Our Ref: 23/02043/HFUL  
Your Ref: 232 Streetly End Farm

**South Cambridgeshire District Council  
Application for Planning Permission**

Proposal: Replacement single storey outbuilding.

Site address: Streetly End Farm Streetly End West Wickham Cambridgeshire

LOCATION AND
 EXISTING BLOCK PLAN

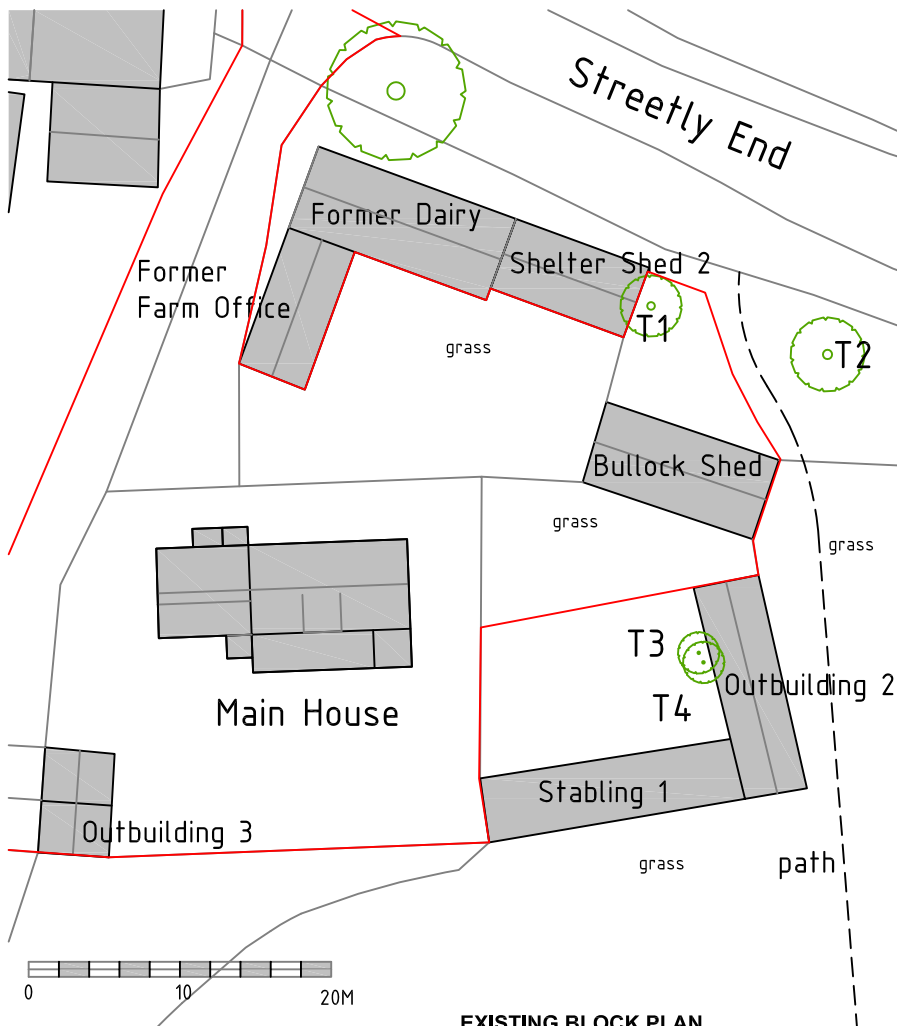
1. If the application is for an outbuilding serving Streetly End Farm, then the red line in location plan must show a functional link to a dwelling for it to be considered as a householder application.

Furthermore, it should include all land necessary to carry out the proposed development - Including any land required for access to the site from a public highway,
